CITY OF ALBUQUERQUE

February 17, 2017

**RE: APS Family School East Side
3303 Monroe St NE
Drainage Plan and Report
Engineer's Stamp Date: 1/30/2017 & 12/12/2016
Hydrology File: G17D019A**

**CD1**

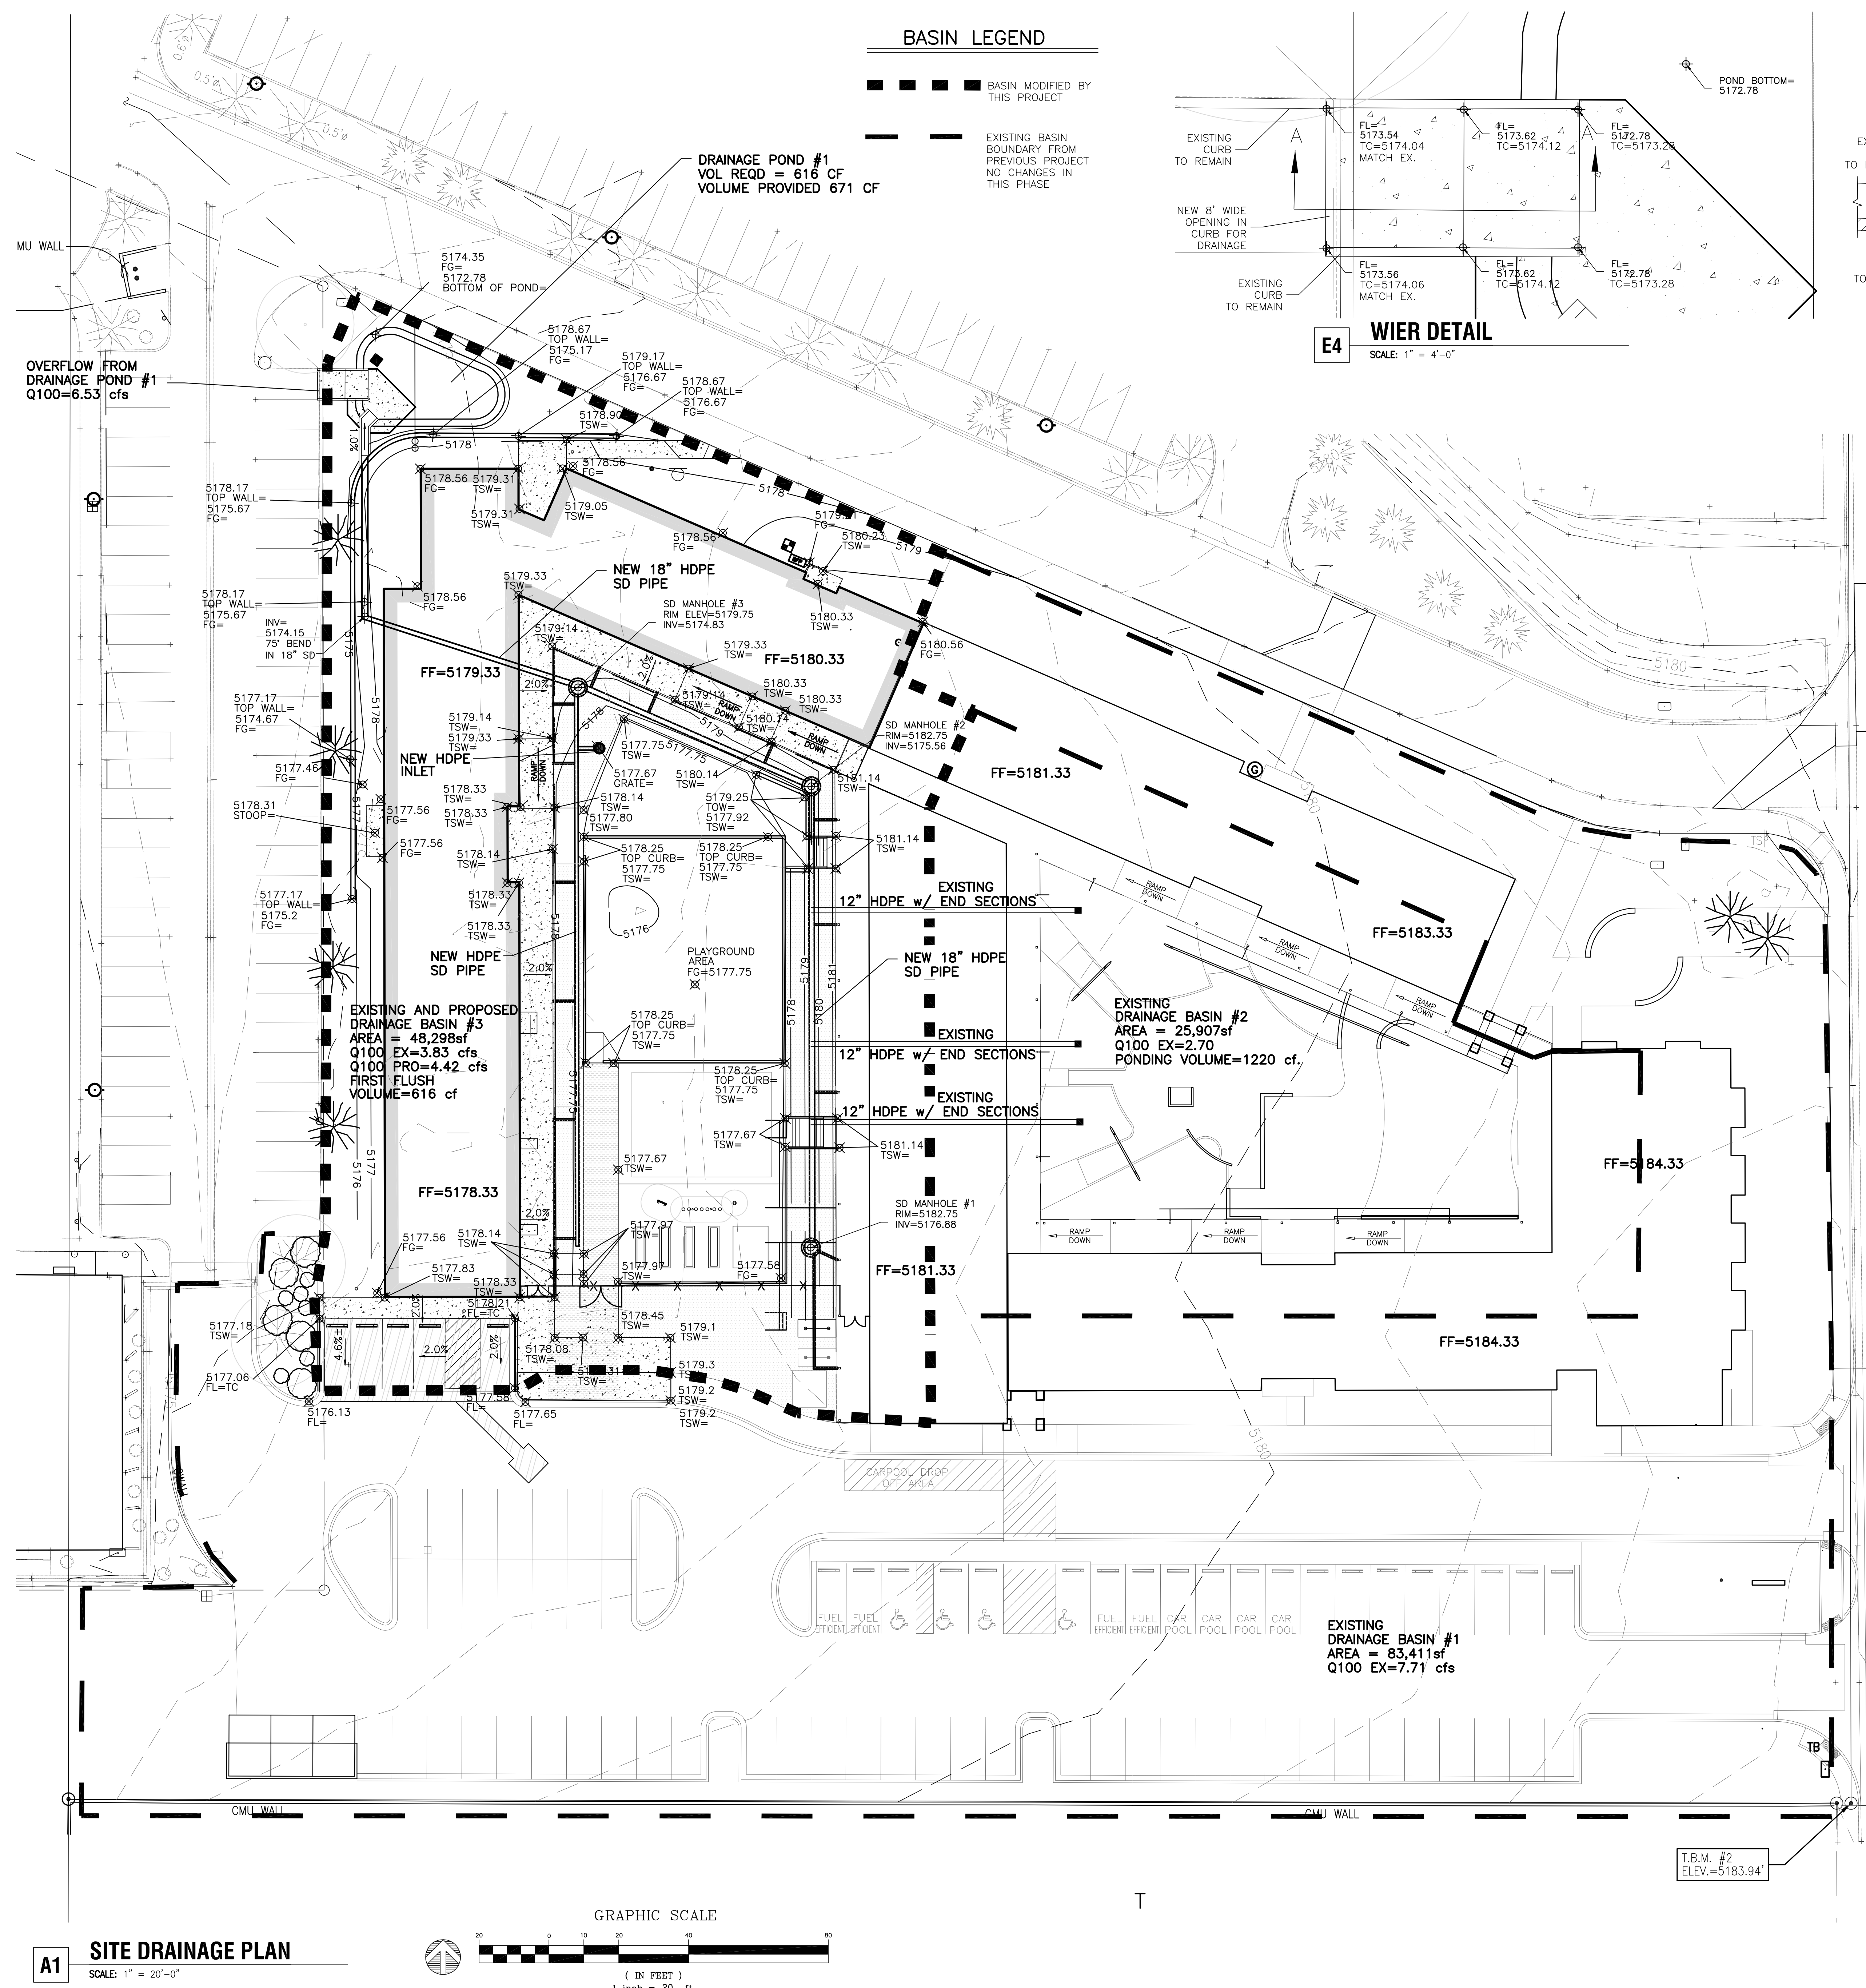
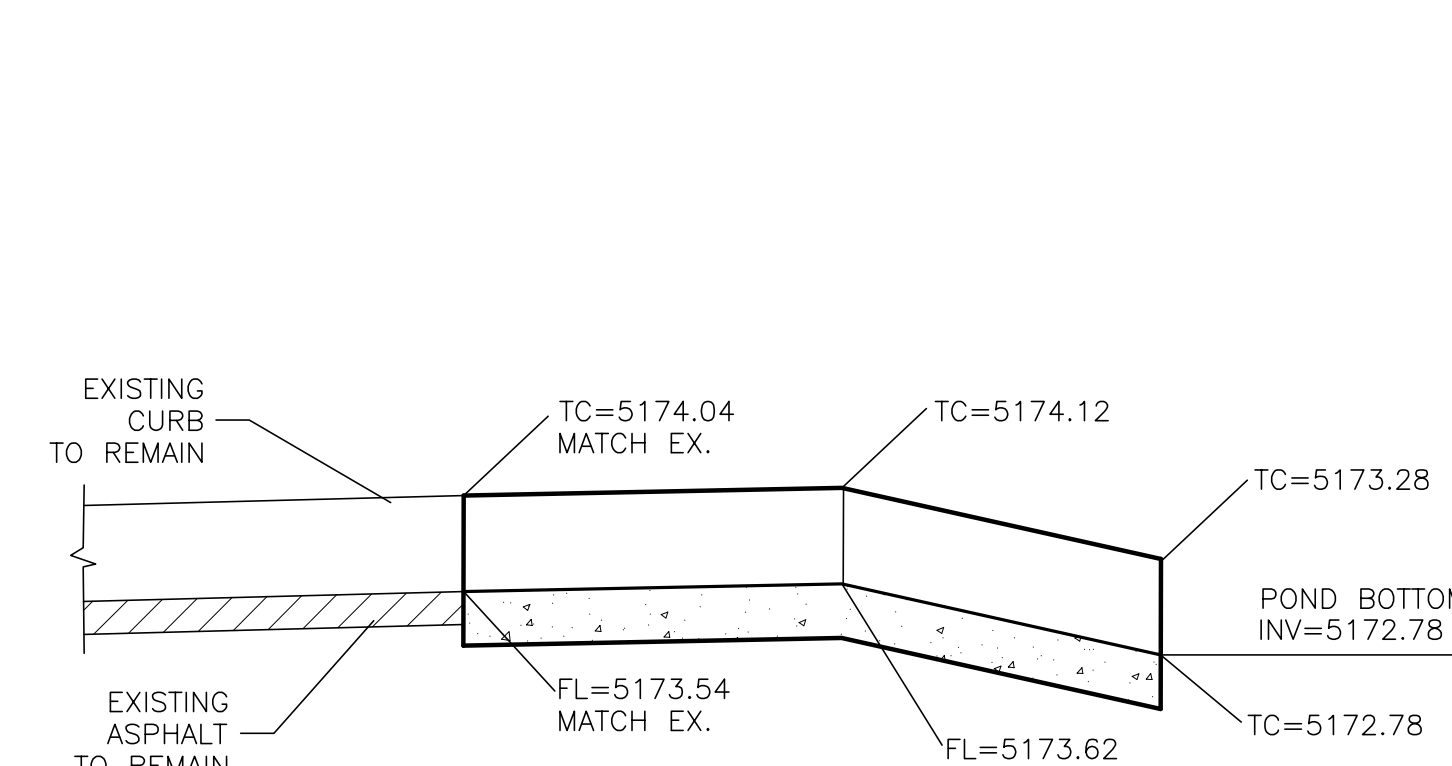
1. Define the limits of construction and provide area. Submittal of an erosion and sediment control plan is required prior to building permit approval if the disturbed area is over 1 acre. Please contact Curtis Cherne P.E at 924-3420 for question regarding ESC plans.
2. Clarify how the storm drain outfalls through the wall and into the pond with a detail view/notes and include dimensions and inverts. In your previous submittal, this information was added for the overflow weir, but not the storm drain outfall.

1. Use RVP Class IV underneath the building and the wall
2. Call out Section and detail views for the weir
3. Correct invert elevation on SD Manhole #2
